Subject: **Addendum to Geotechnical Investigation Report**  
1871 Merivale Road, Ottawa, ON  
Proposed Benson Auto Parts  
Response to Review Comments Received on June 23, 2017

This addendum provides responses to the review comments submitted by the City of Ottawa, dated June 23, 2017. This supplements and provides additional information to the "Geotechnical Investigation Report" completed and submitted by LRL Associates Ltd. (LRL) on October 2014, for the proposed Benson Auto parts Expansion, located in above referenced address.

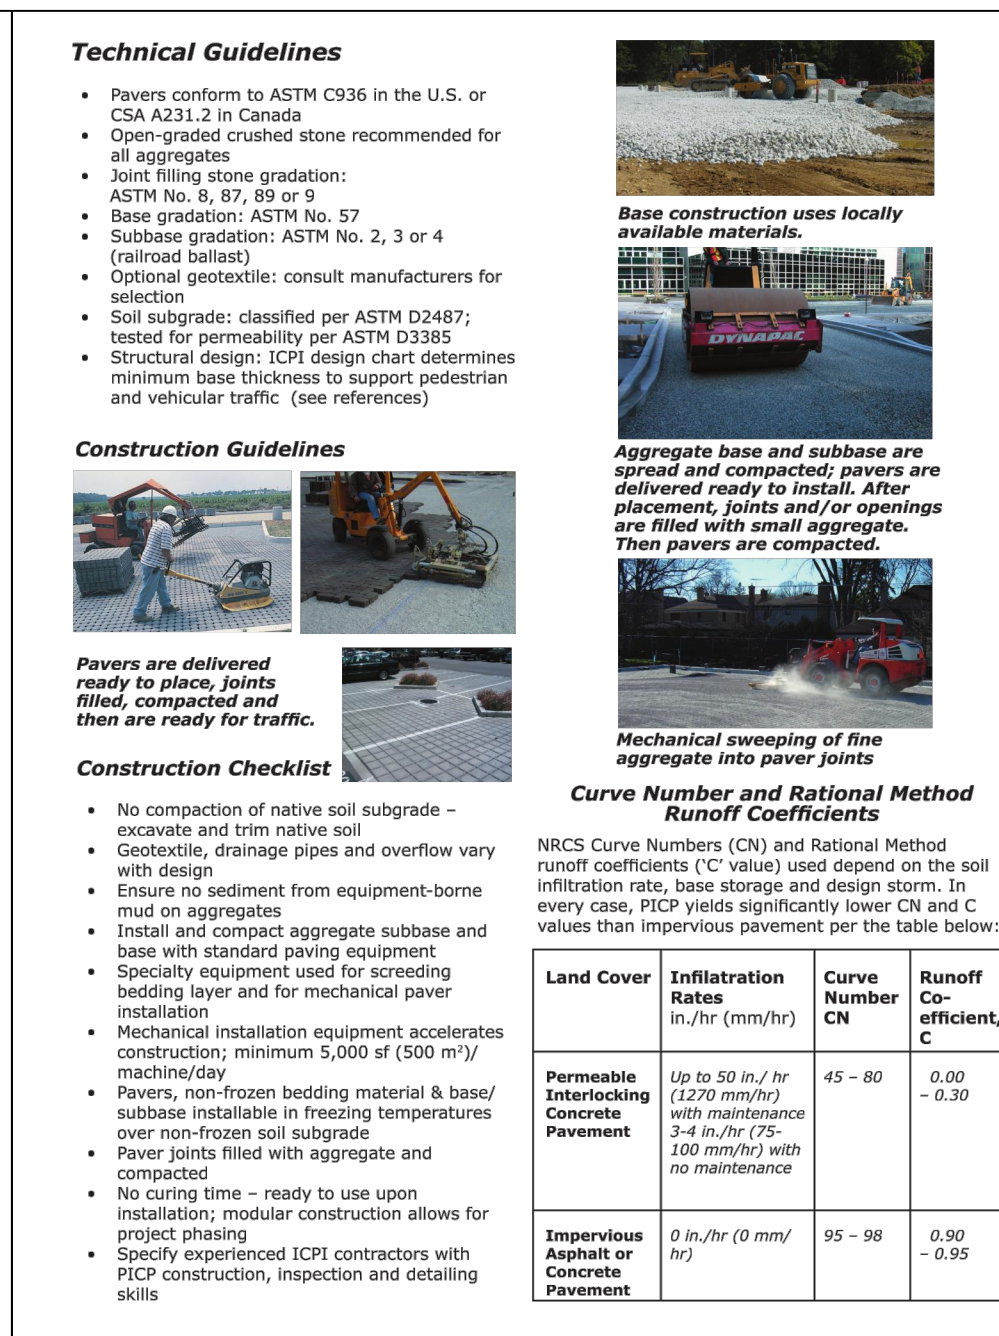
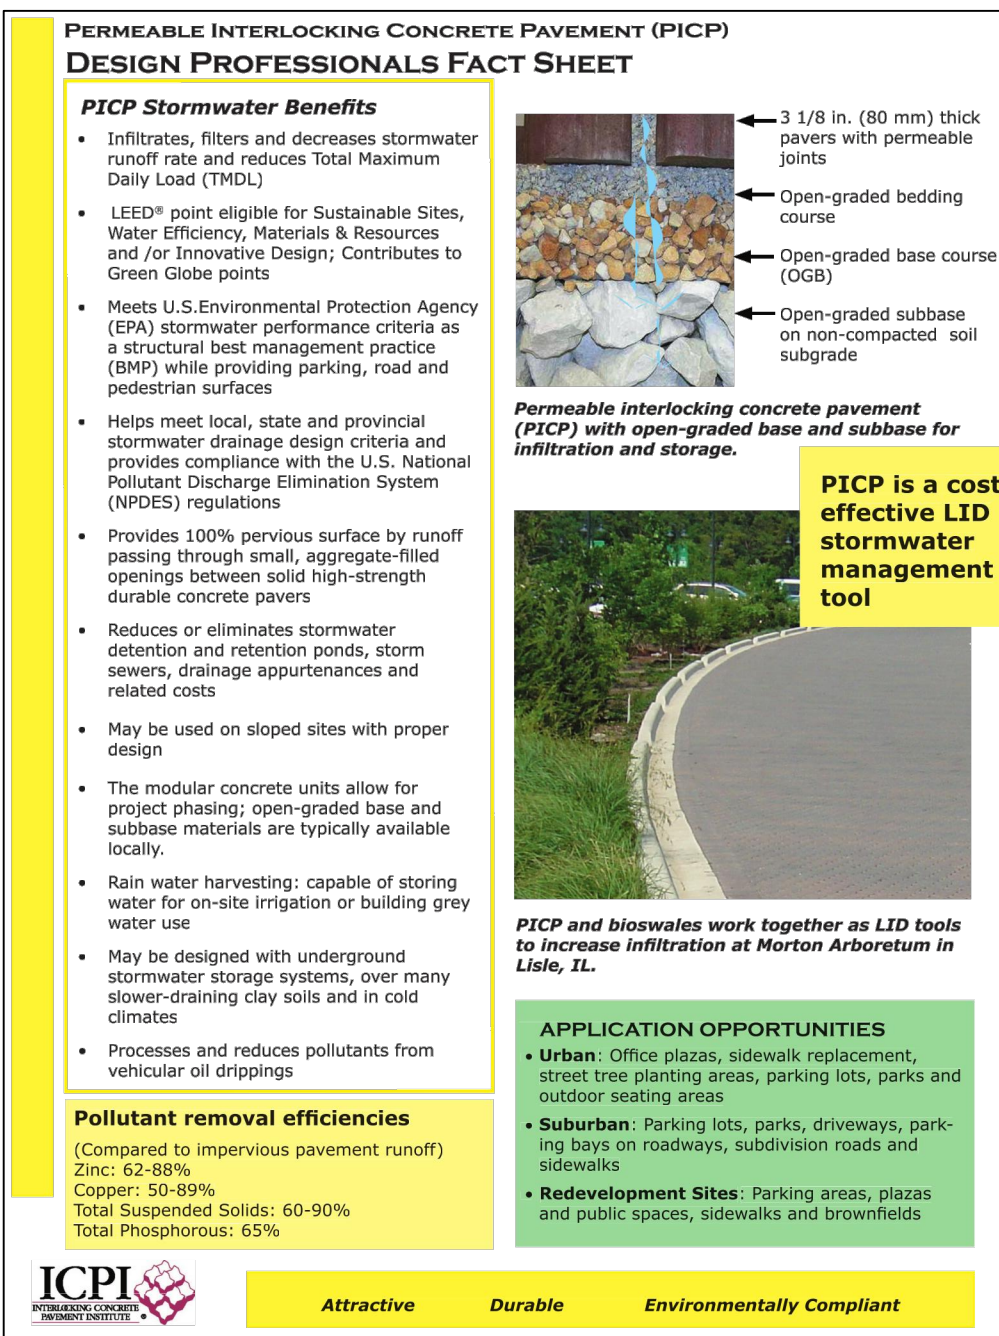
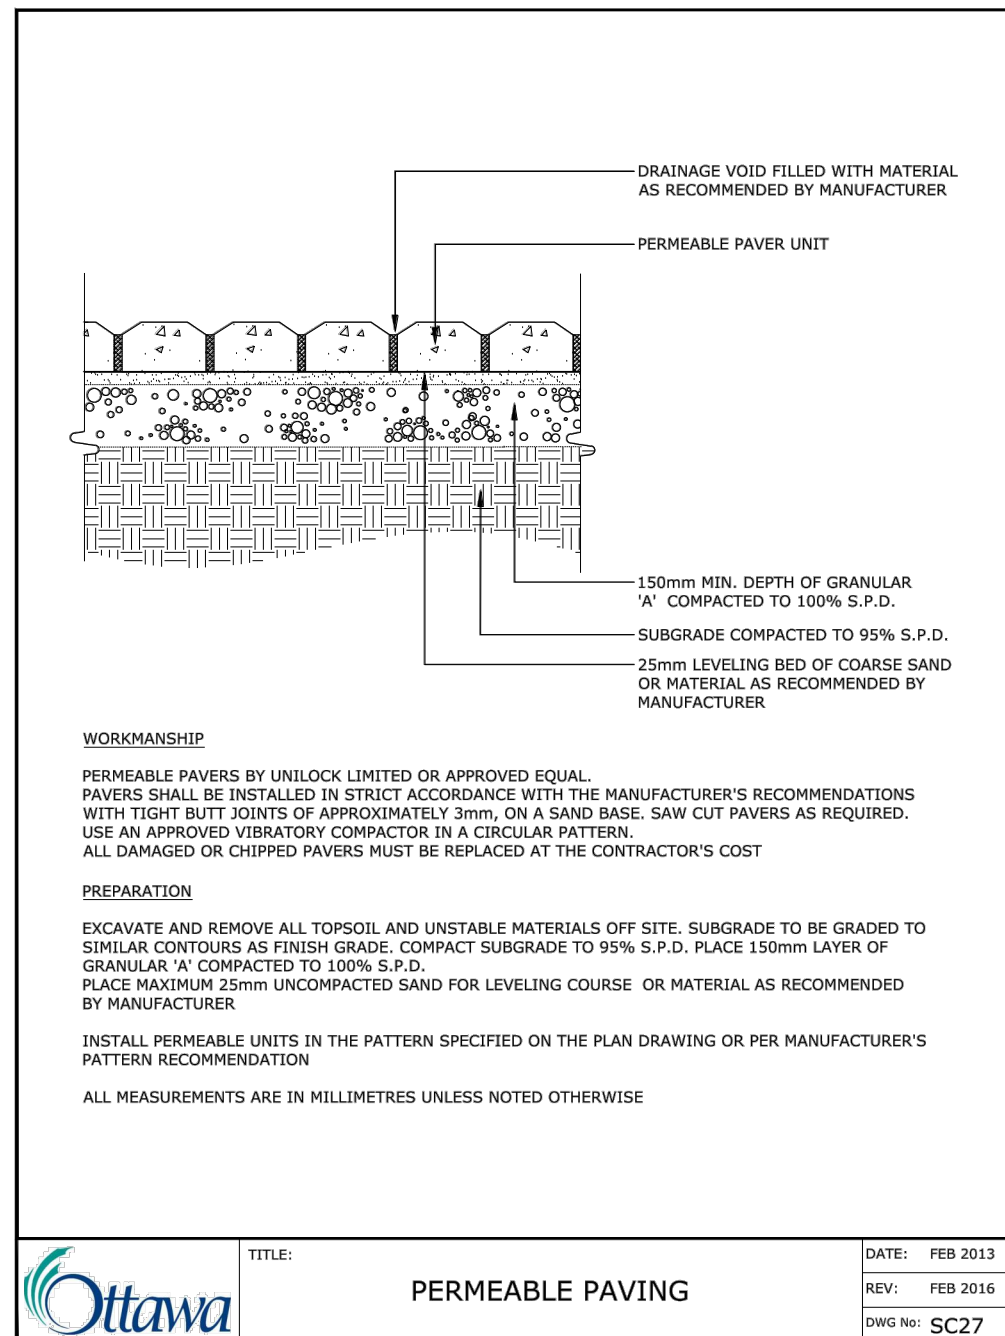
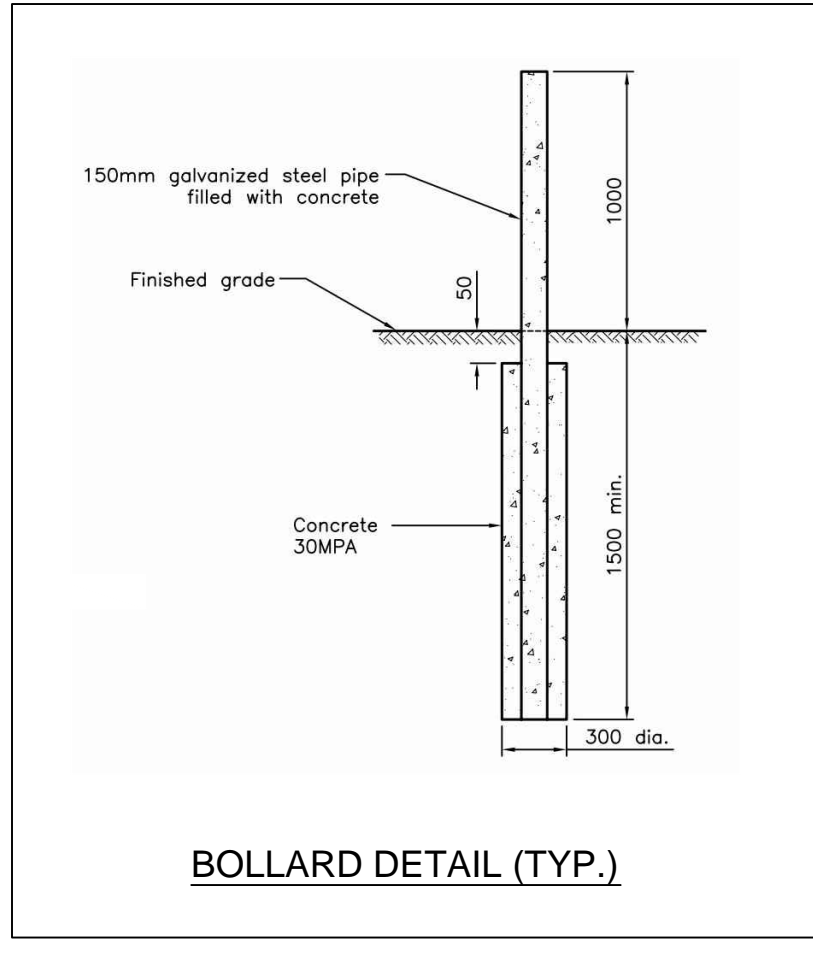
7. Please review the proposed underground StormTech storage chamber system and provide confirmation via a memorandum that the established seasonally high groundwater table depth elevation is a minimum 1m below the bottom of the proposed system as per MOE Stormwater Design Manual. Based on information provided within the report the seasonally high groundwater level has not been established.

*Response: The bottom elevation of the proposed StormTech storage chambers is at 85.80m; 2.72m above the groundwater table elevation measured at the time of the subsurface investigation. To account for seasonal fluctuation, 1.5m is added to the groundwater table elevation; still the bottom of the storage chamber will remain a minimum of 1.0m above the high groundwater table.*
